We [REDACTED] are the owners of the property, [REDACTED] London.

We are resubmitting application PA/20/01406/NC, providing further details in the form of photographs from the surrounding area demonstrating that the proposed roof extension will not be visible from the surrounding area, and particularly from the locations mentioned in the Officer's Report.

## Supporting Statement

**Drawing No.:**  
PHP MOR 02 102

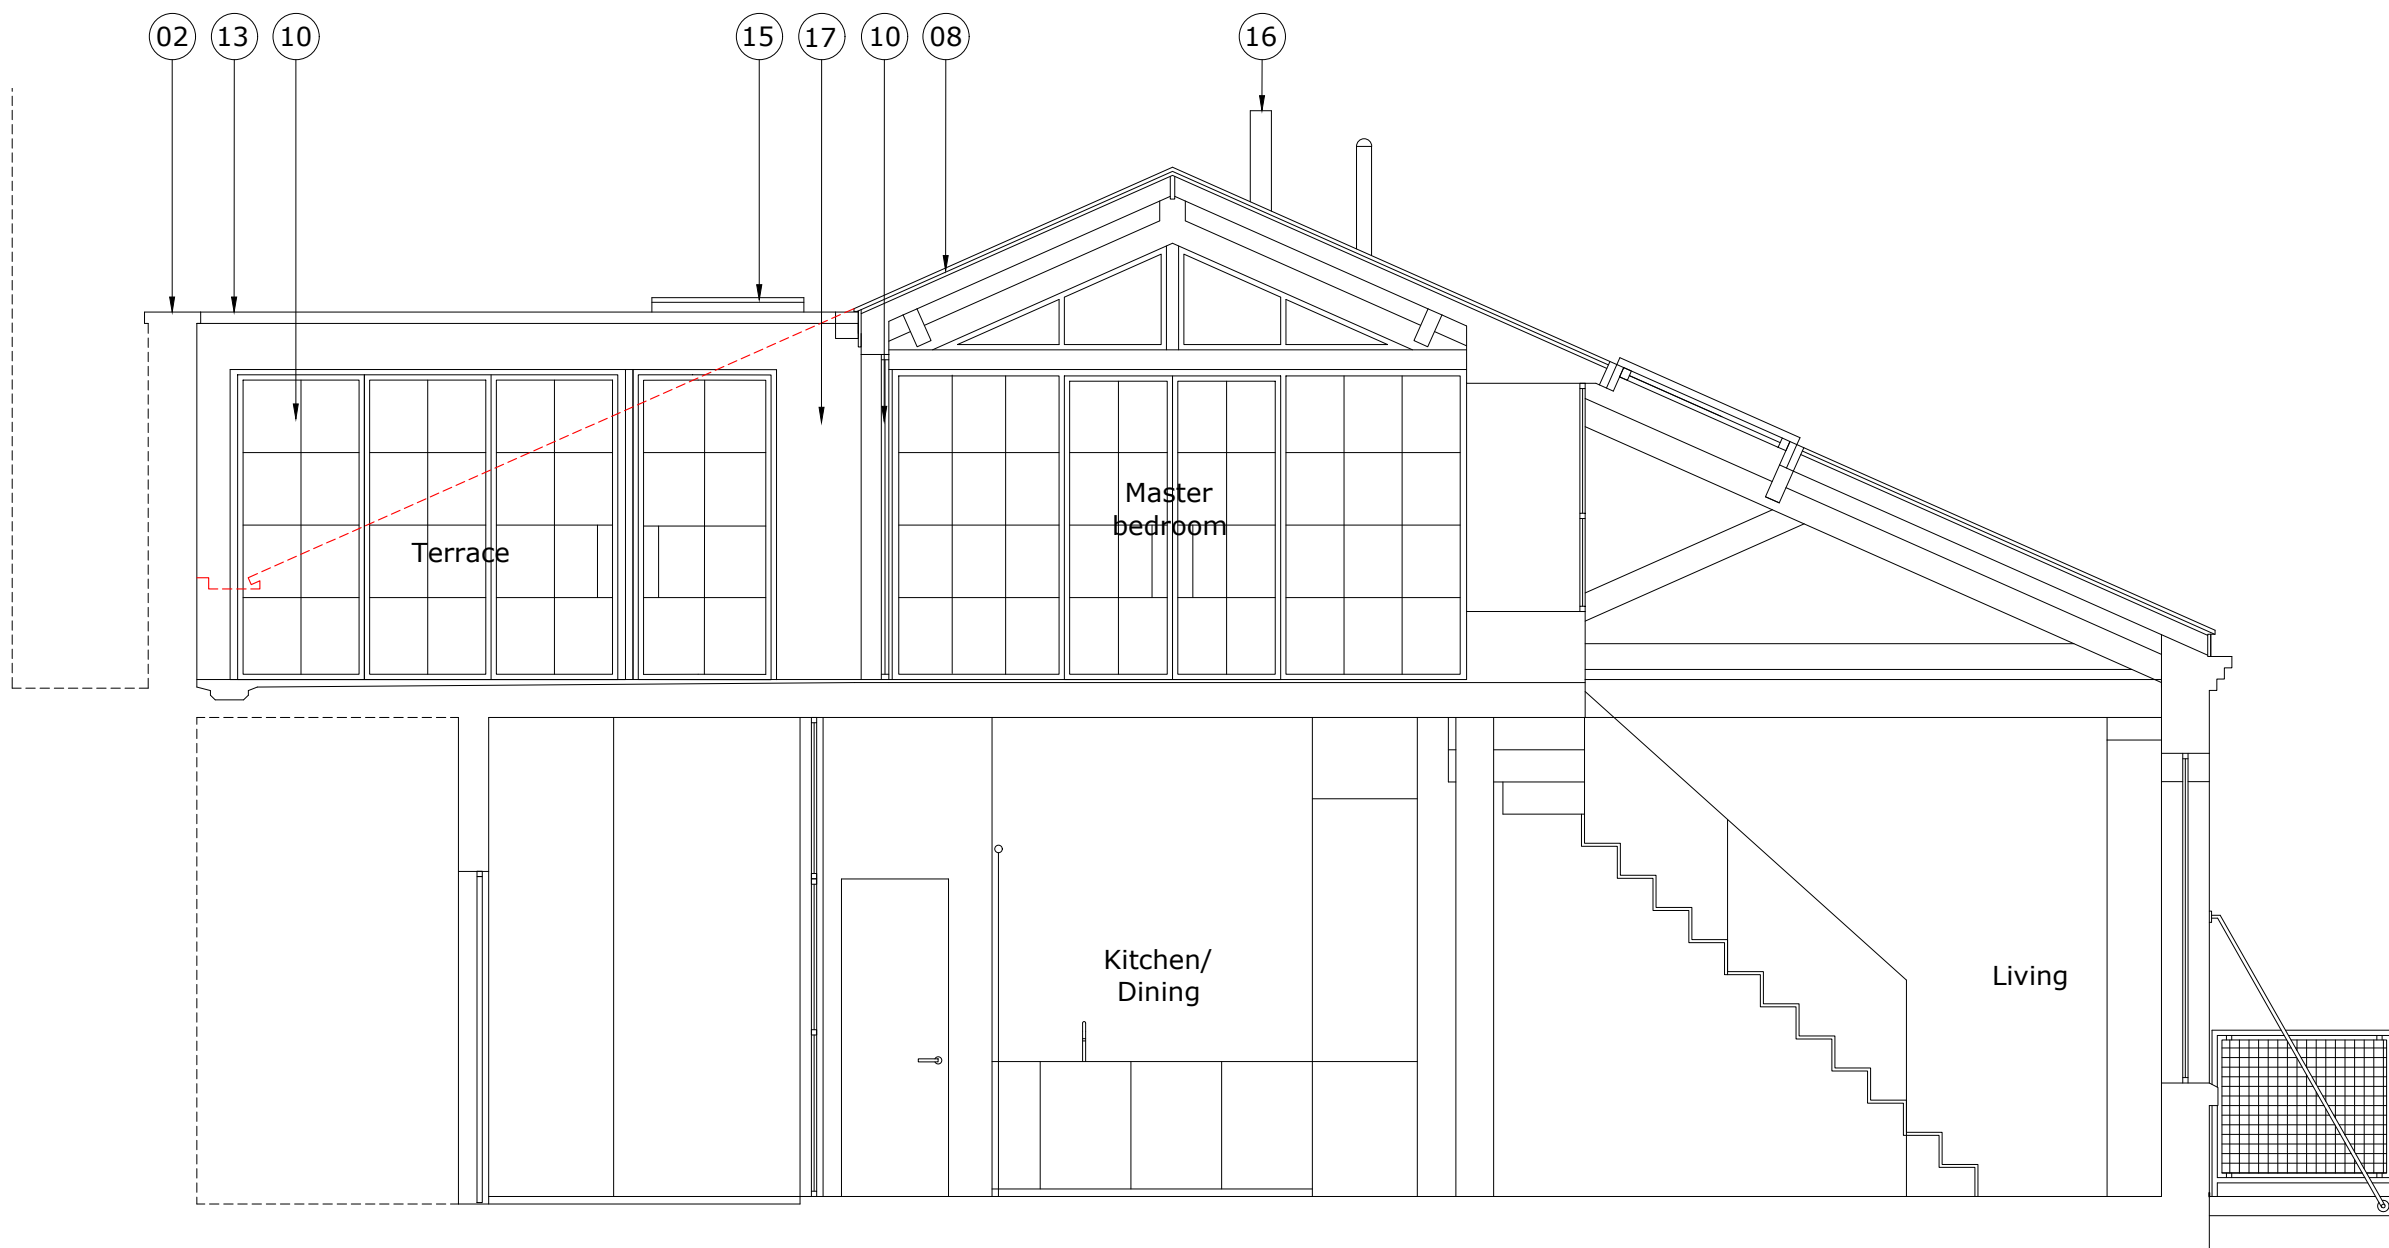
- 5.1 *LBTH Design and Conservation: Refuse planning permission. The proposal would alter the roof form of this historically significant landmark building, which currently has an unaltered roofline and which is prominently located within and adjoining conservation areas. It would as such fail to meet the objectives of S72 of the Planning (Listed Buildings and Conservation Areas) Act 1990 (hereafter the PLBCAA).*

7.6 *The site sits on the southern side of Limehouse Cut and the height of the proposed roof extension is proposed to sit below the existing brick wall enclosure/parapet line and therefore will have limited visibility from the immediate neighbouring roof terraces. However, the proposed roof extension is likely to be somewhat visible from buildings across the canal to the north and at street level on the path parallel to the canal and the new public open space at Caspian Wharf. The applicant has not provided evidence in the form of ground level views, to indicate that this would not be the case.*

7.7 *Moreover, a key aspect of this building is its consistent roof form which is uniformed and shows cohesion within the surrounding rooflines, both in materiality and form. Policy S.DH3 states development within a conservation area will be expected to preserve or, where appropriate, enhance those elements which contribute to their special character or appearance.*

7.11 *The proposal would alter this uniform roofline and would be out of keeping with the character of the host building and surrounding buildings in the conservation area. Taking this into account, the proposal is not comply with policies S.DH1 and SDH3 of the Local Plan 2031, section 72 of the PLBCAA Act 1990, the relevant paras of the NPPF nor the Langdon Park Conservation area character appraisal and management guidelines (2009).*

**Response:** Our proposal has zero impact on the street and wider townscape, as demonstrated with photos (see support documents: vii–xiv) from street level from within the Conservation Area, bordering area, and in the neighbouring public open space of Caspian Wharf. The site is not visible from any direction at street level. A site visit will confirm this.

**Response:** According to the Langdon Park Conservation Area map the proposed extension is not visible from within the Conservation Area. The Appraisal

mentions significant long views from Violet Road and the canal path, but the proposed extension is not visible from either. The proposal would not be visible from street level in any direction and has limited to no visibility for adjacent studios and rooftops. On this basis it is difficult to understand for who the roofline is being affected.
